KIRKLEES METROPOLITAN COUNCIL INVESTMENT & REGENERATION SERVICE

DELEGATED DECISION TO DETERMINE APPLICATIONS FOR LISTED BUILDING CONSENT

Reference No:	2022/65/92391/W
Site Address:	Coffee Novo, 50, New Street, Huddersfield, HD1 2BW
Description:	Listed Building Consent for internal and external alterations to convert coffee shop to building society including new shopfront, fire exit door and A/C condenser units [within a Conservation Area]
Recommending Officer:	Tom Hunt

2022/92391 – Coffee Novo, 50, New Street, Huddersfield, HD1 2BW

RBS Job no.	Project	Originator	Volumn	Level	Type	Role	Suitability	Number	Rev.
142571D	HUD	RBS	XX	XX	XX	X	XX	202	B

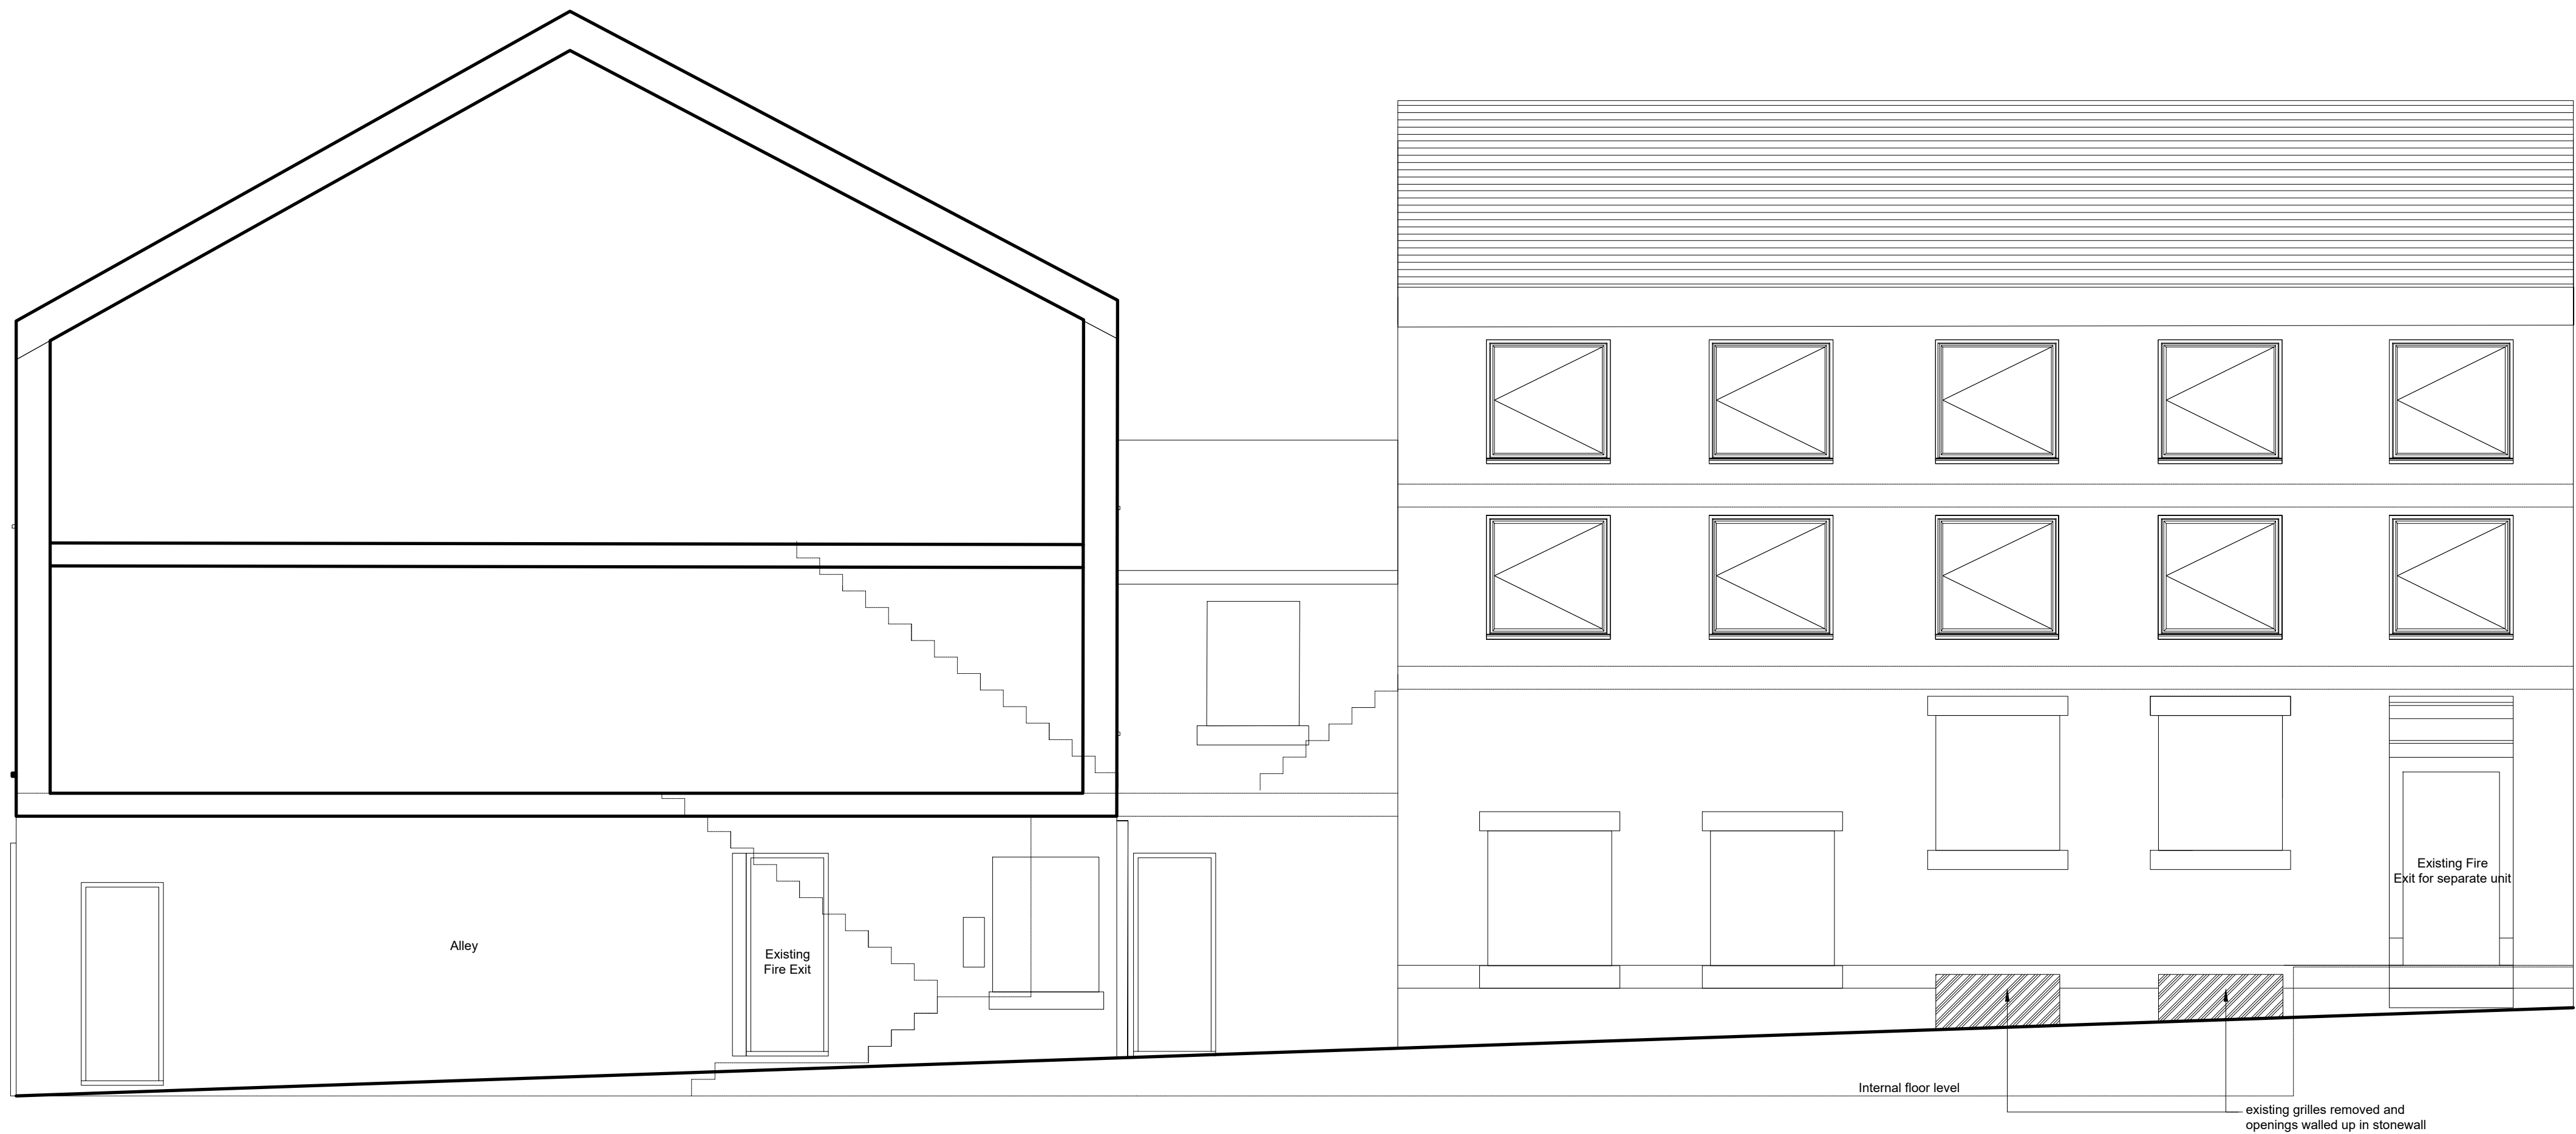
Justification was sought for the originally proposed siting of the fire escape within the Listed Building Section. Following discussion with the Conservation & Design Officer and a request for public benefits to be set out, an originally proposed fire exit to the primary elevation of the Listed Building No. 1-2 was removed.

- Conservation & Design – Required more information why fire exit door was needed. No objection to amended scheme which removed this door.

The applicant proposes to have minimal natural stone infill inserted to existing modern metal grilles. This would be sited to the west of the entrance door and would not interfere with existing stone infilled windows showing the historic elevation. While this would add some minor incongruity with further stone infill, this is mitigated by the removal of the metal grilles which are considered to appear as a modern addition and would not interfere significantly with the primary elevation of the Listed Building.

3. Notwithstanding the submitted detail, the infill of the metal grilles identified on elevation plans shall be of coursed natural stone of the same type, texture, colour and appearance laid to match the exterior materials of the Listed Building.

| Drawing:    |         | Proposed Plans                                             |       |       |        |      |             |        |      |

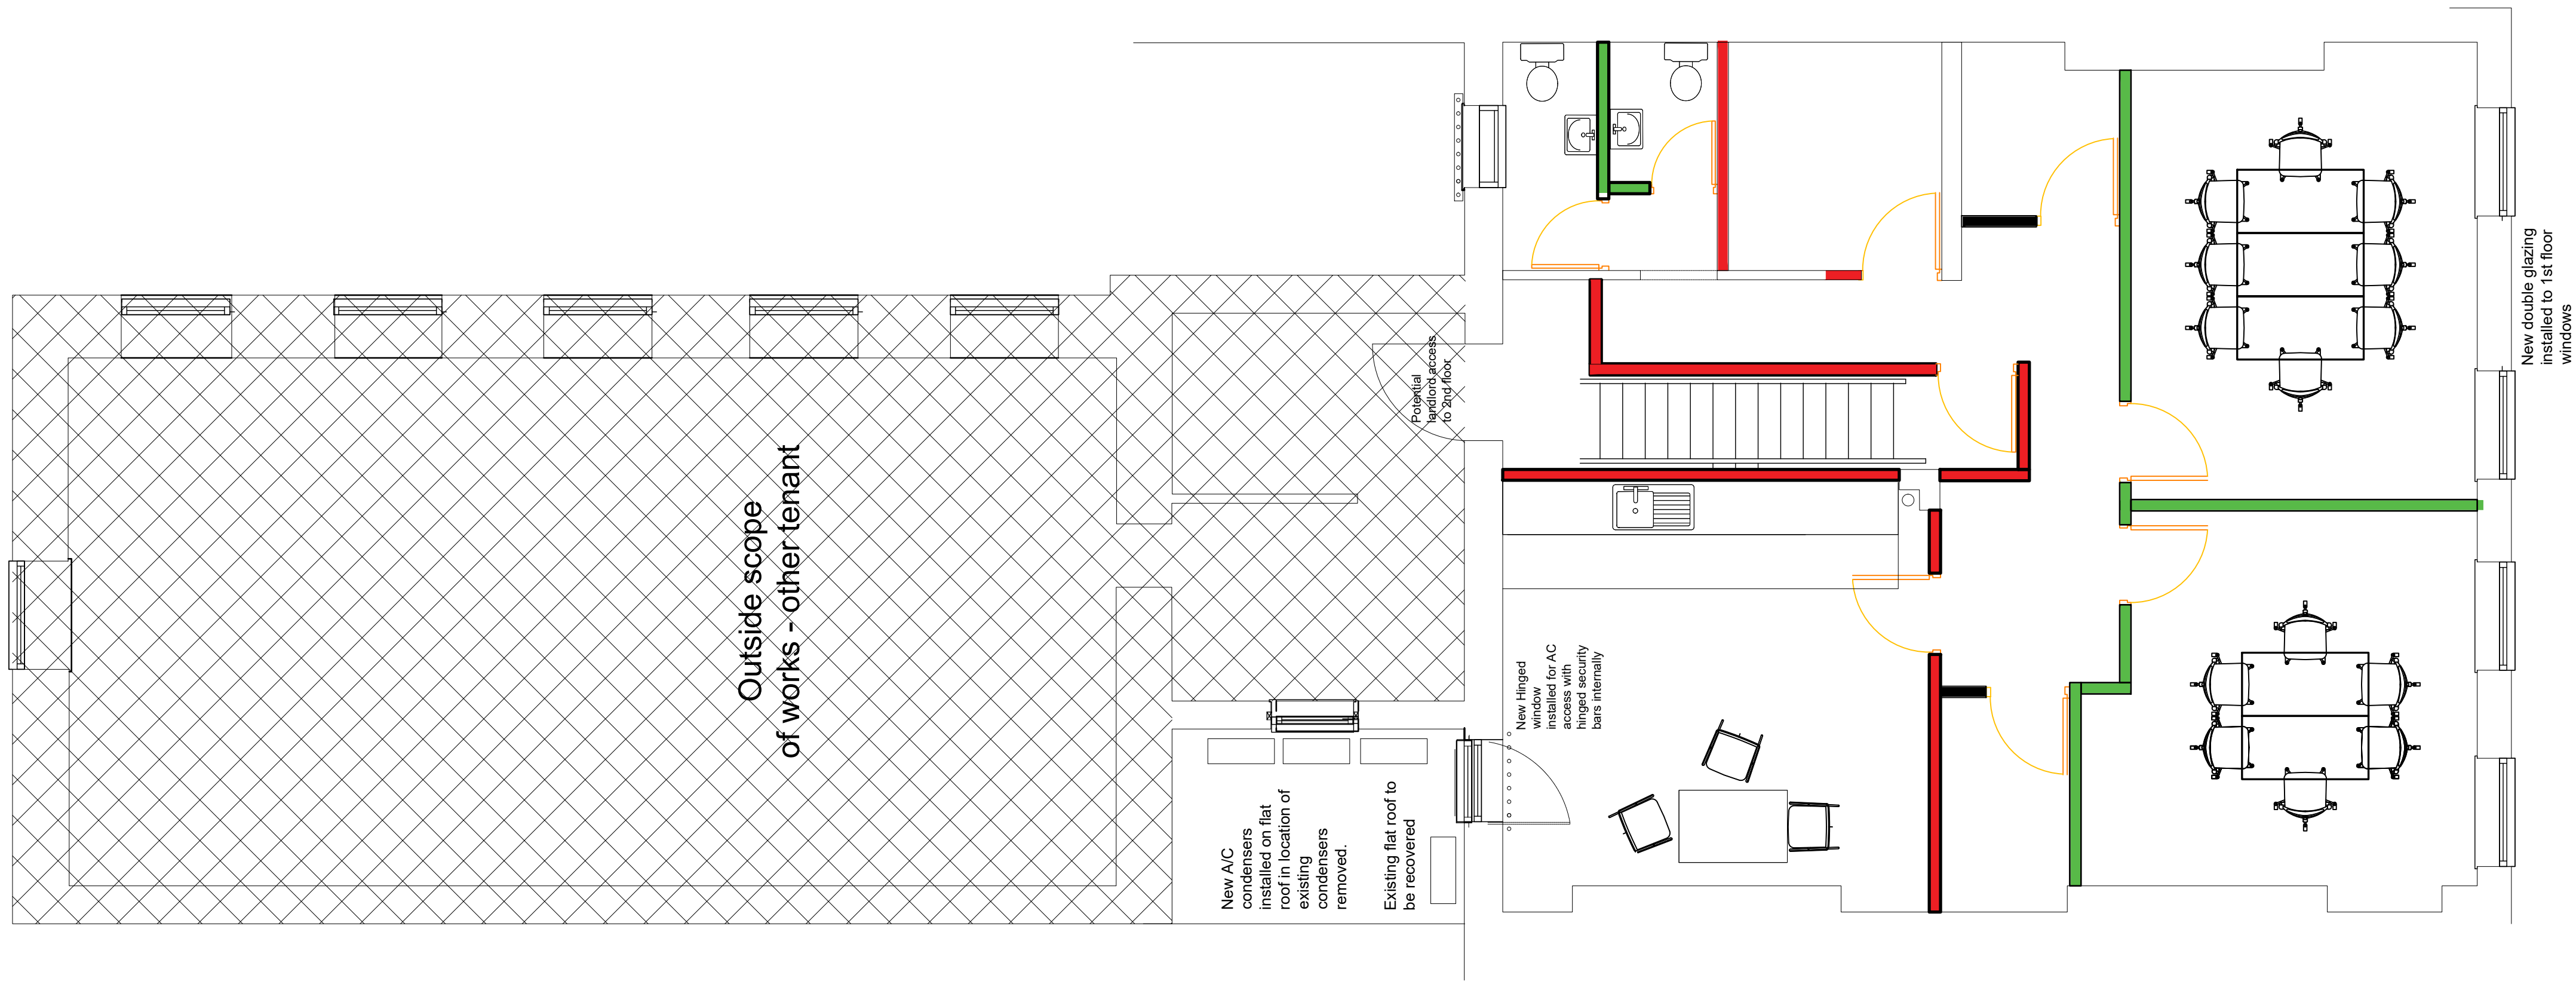
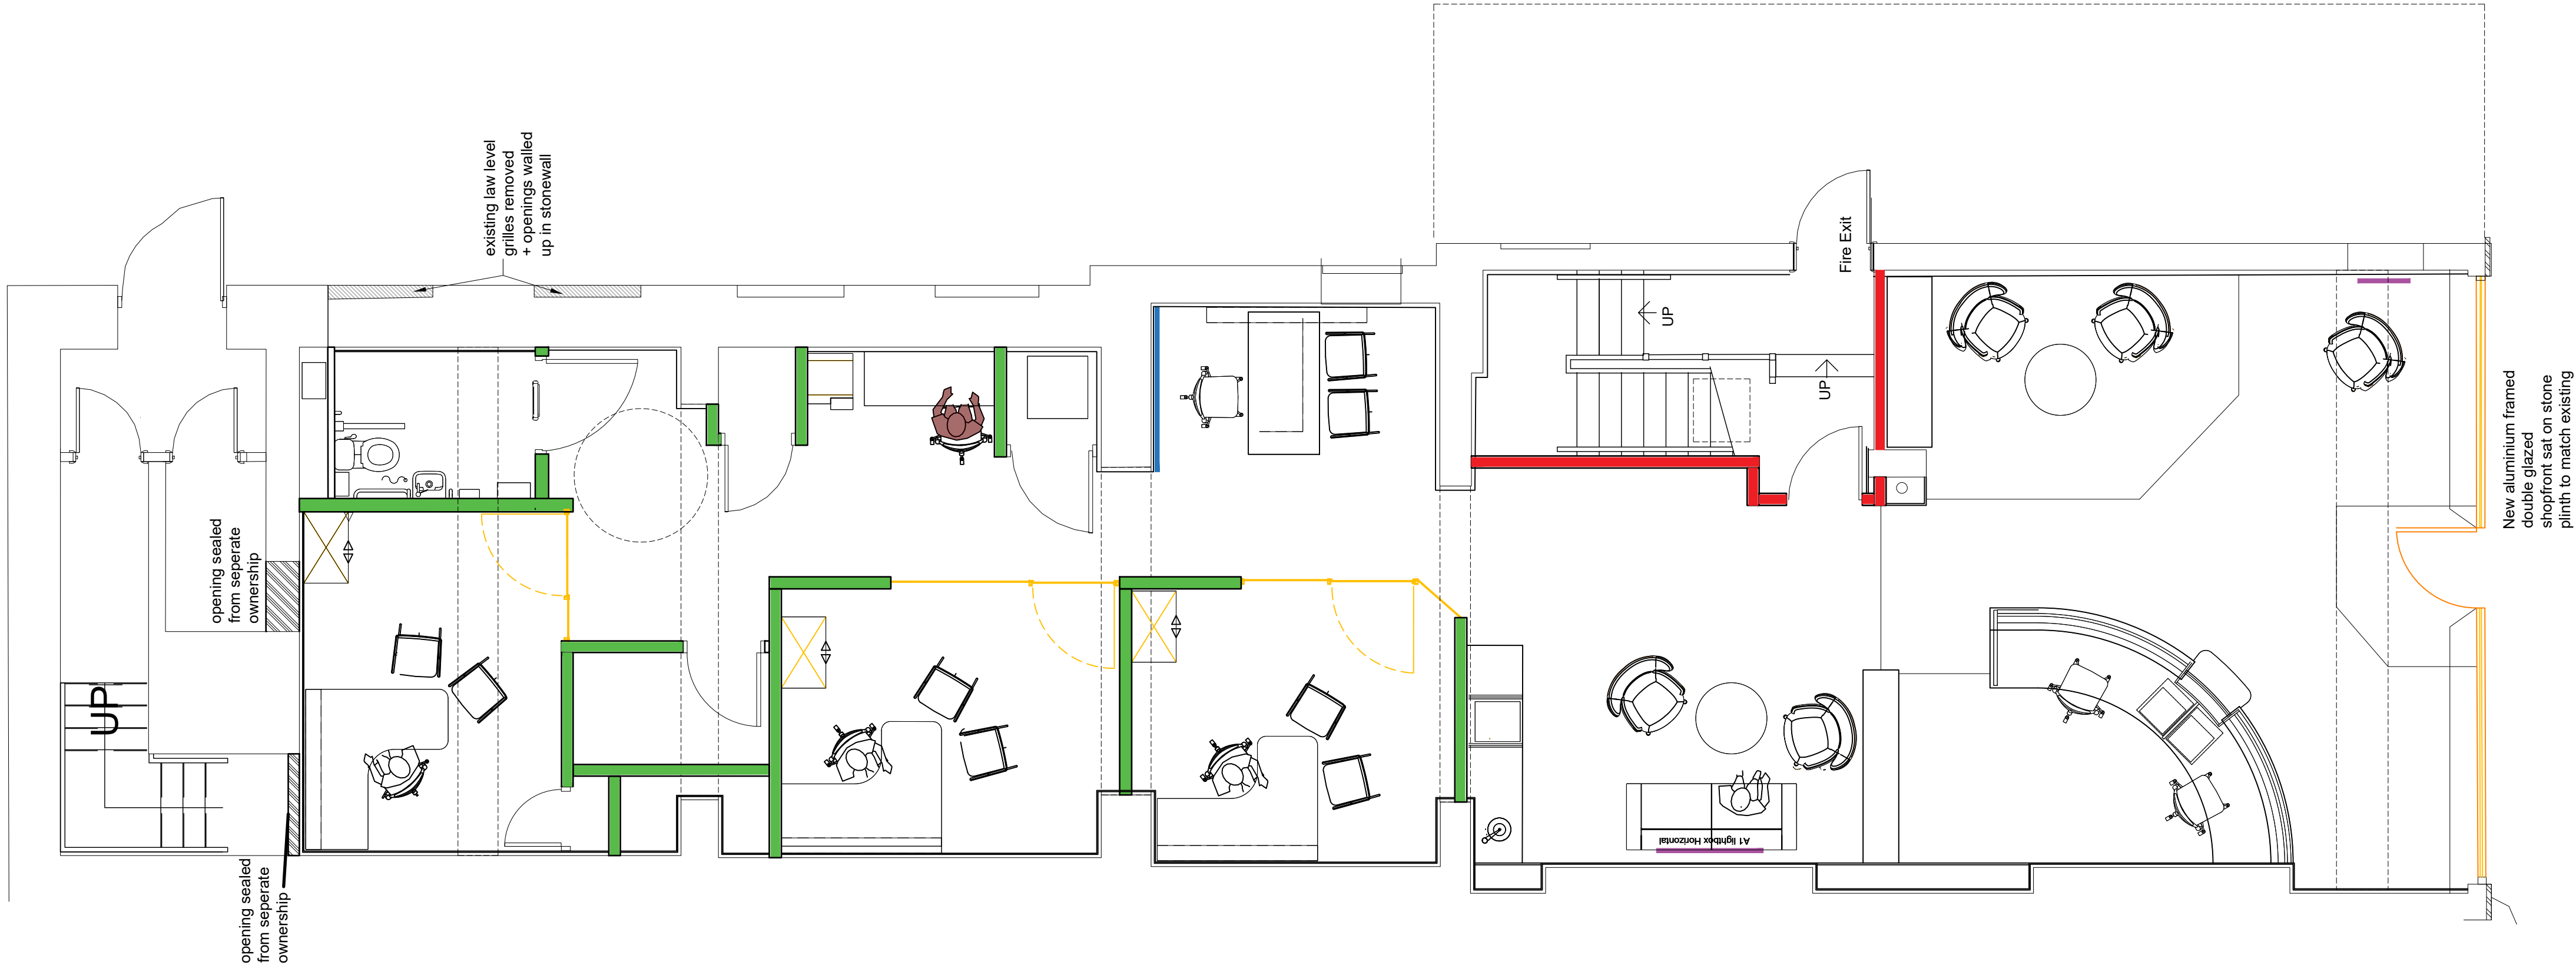
Internally it would have its existing modern shopfittings/dividing modern walls removed and have new reversible wall fittings to sub-divide the room to allow for offices and a WC. In order to allow the function of a financial commercial unit, there would be internal openings to be infilled to prevent access to the side elevation of the Listed Building which would serve to subdivide the building securely from its proposed use upstairs.

4. Where it is proposed to infill existing interior openings, doorways/door frames to subdivide the building, any historic existing frames shall be retained in situ and the doorway/opening infilled using coursed natural stone of the same type, texture, colour and appearance.
